Consultation Response from KC Waste Strategy (Refuse & Cleansing)		
2022/92081 Land at, Huddersfield Road/Leeds Road, Birstall, Batley, WF17 9AA		
Proposal: Demolition of existing buildings and erection of retail food store with associated parking and landscaping		
Date Responded: 30.06.22	Responding Officer: Mike Hibbert	Responding Ref: WPN 22-028
NOTES/COMMENTS: The following comments are made without prejudice and purely from the point of view of the Waste Collection Authority. They are intended to help create an environment that functions safely and efficiently for waste management; Addressing these will also enable the proposal to better meet the policy requirements of LP43 and the Kirklees Highway Design Guide SPD in respect of waste collection and management. Under Section 45 (1) (b) of the Environmental Protection Act 1990 It shall be the duty of each Waste Collection Authority (WCA), if requested by the occupier of premises in its area, to collect any commercial waste from the premises. The applicant/ tenant may choose to use the trade waste service from Kirklees Council, a private contractor or reverse logistics for collection and treatment of wastes arising on the site.

Title Proposed Site Plan		Client Wharfedale Ltd.	
MWA Project Ref 6228	Scale 1:200	Original Paper Size @A1	Paper Orientation Landscape
Files Identifier Project	Originator	Volume	Level
WLLR - MWA - XX - XX - DR - A - 1001			
Revision	Role	Number	Revision
P6

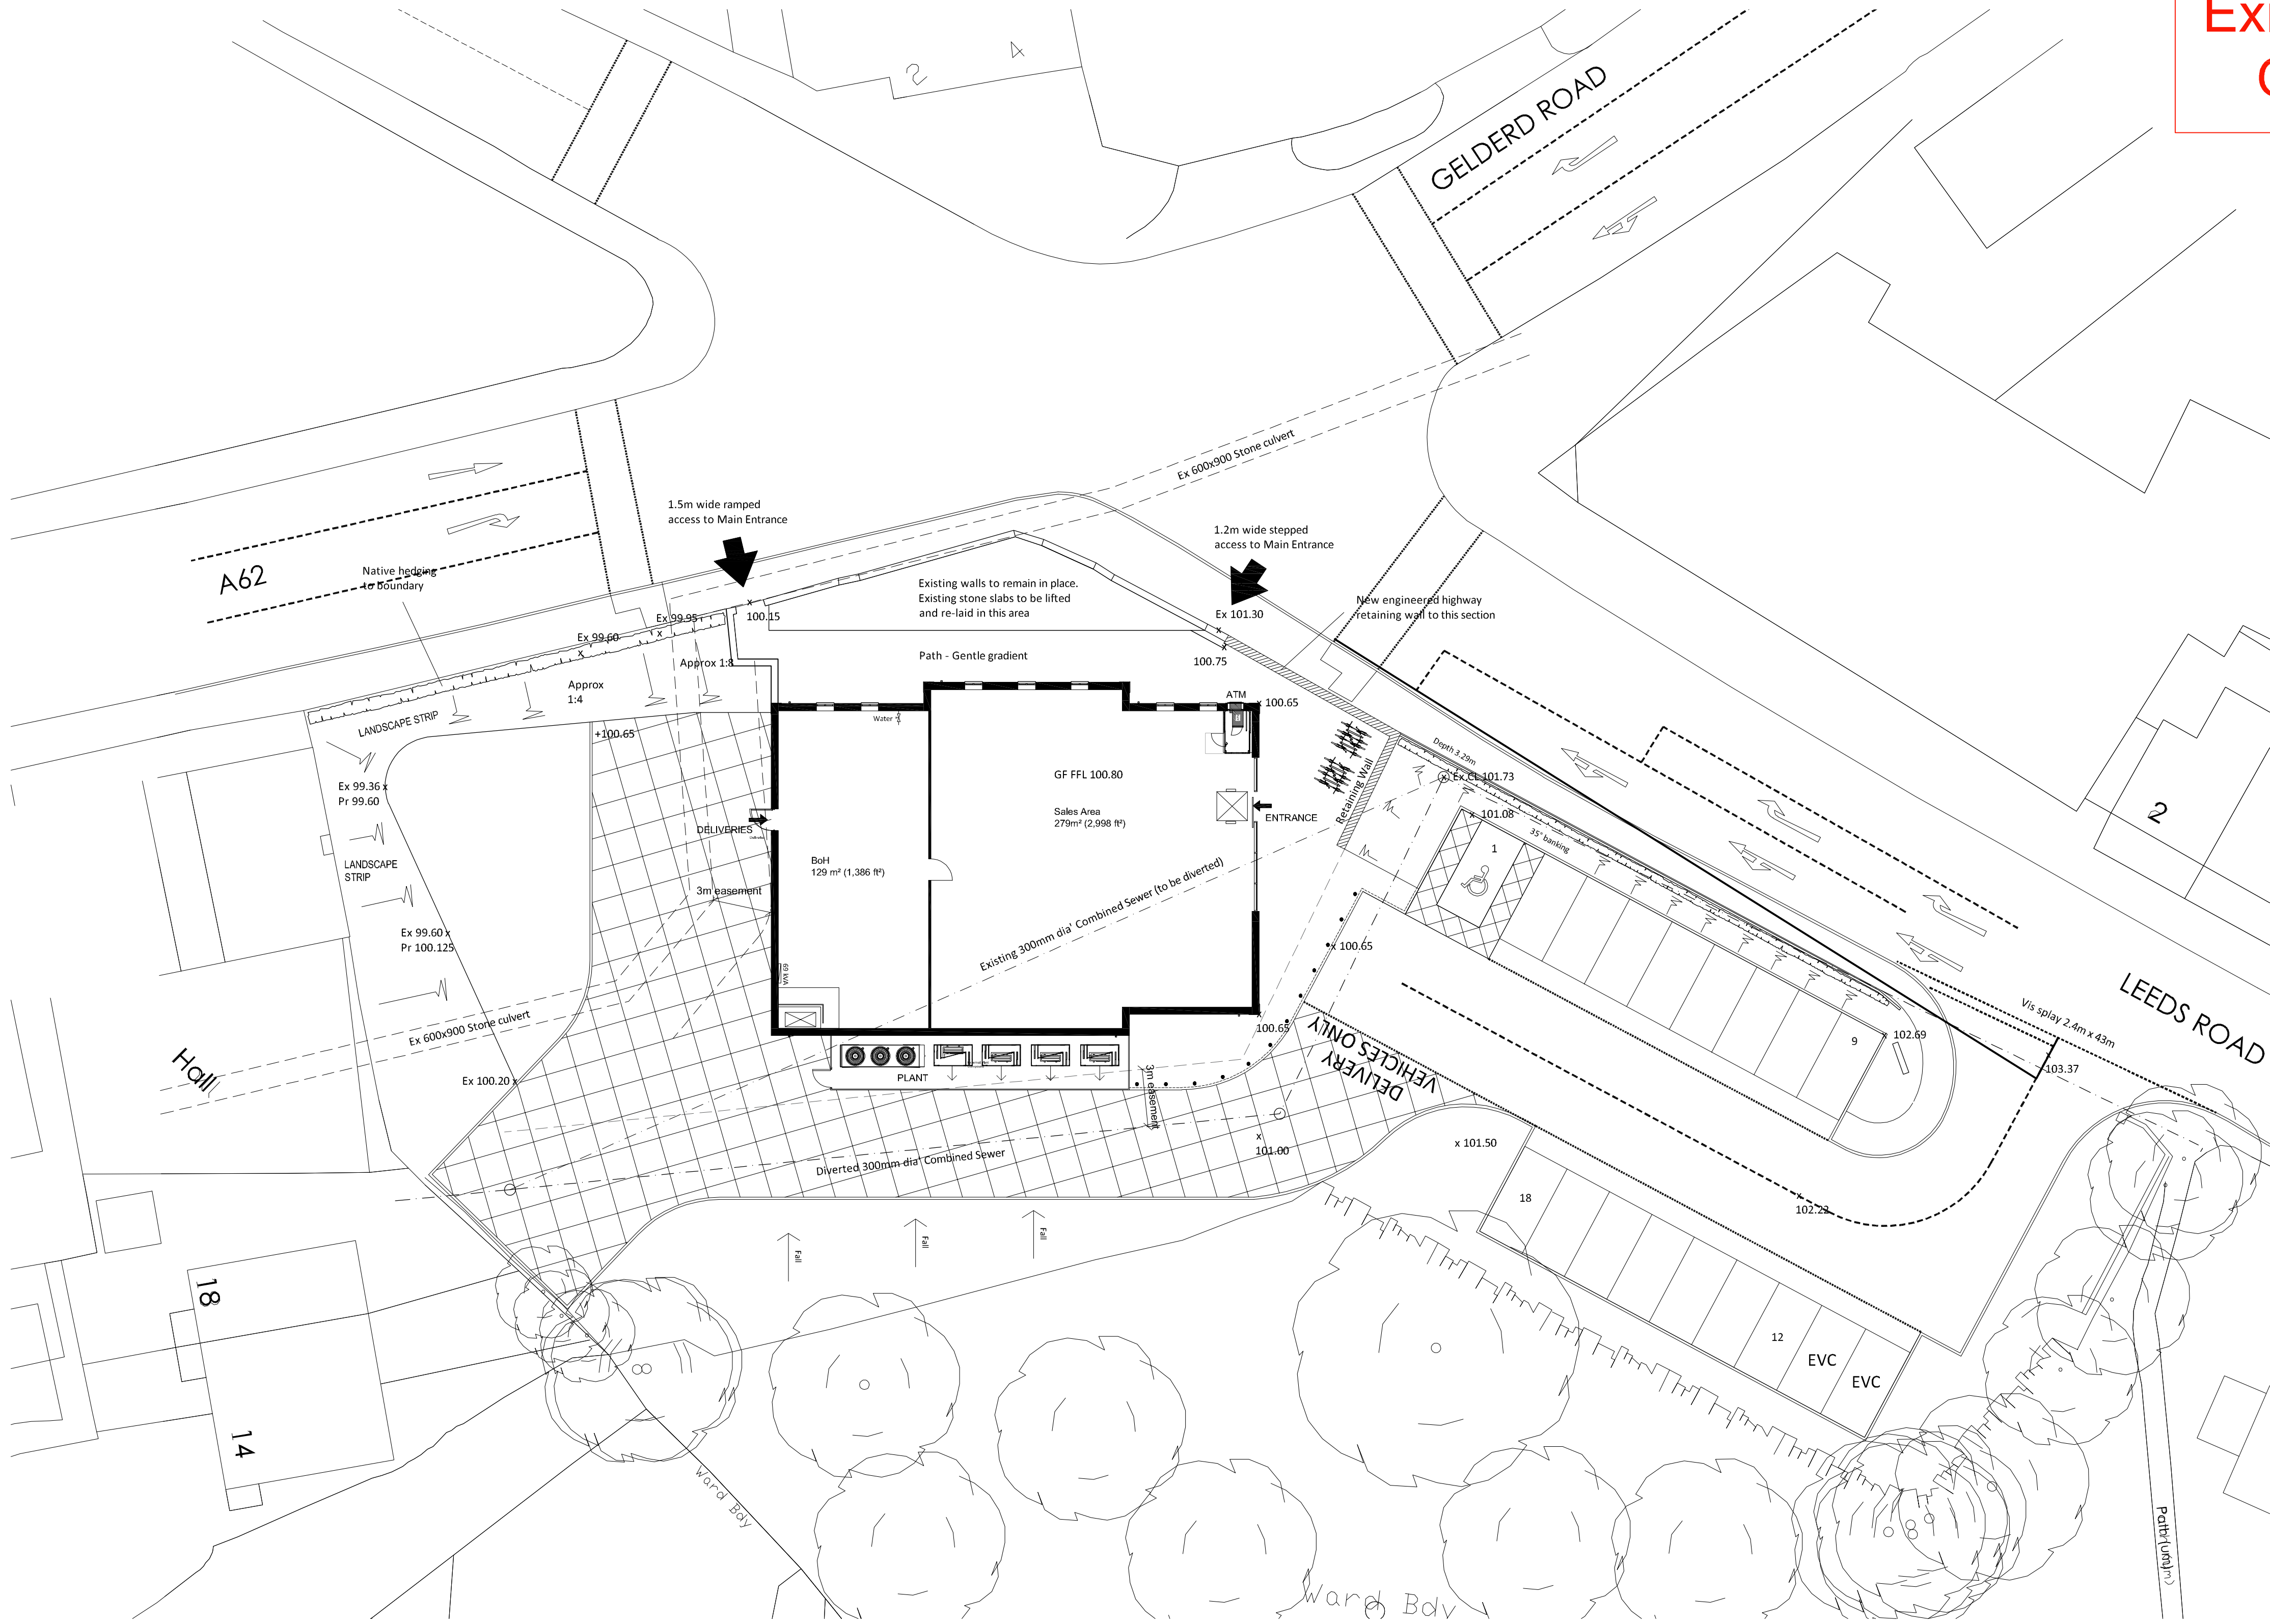
The Westminster government has proposed introduction of legislation for the implementation of a deposit return scheme (DRS) in England that will impact on the vendors of beverages. Clarification is sought as to how some form of reverse vending equipment to enable collection of polyethylene terephthalate (PET) / High-Density polyethylene (HDPE) plastic bottles, steel/aluminium cans and possibly glass bottles will be incorporated into the store layout and how the collected wastes will be stored on site.
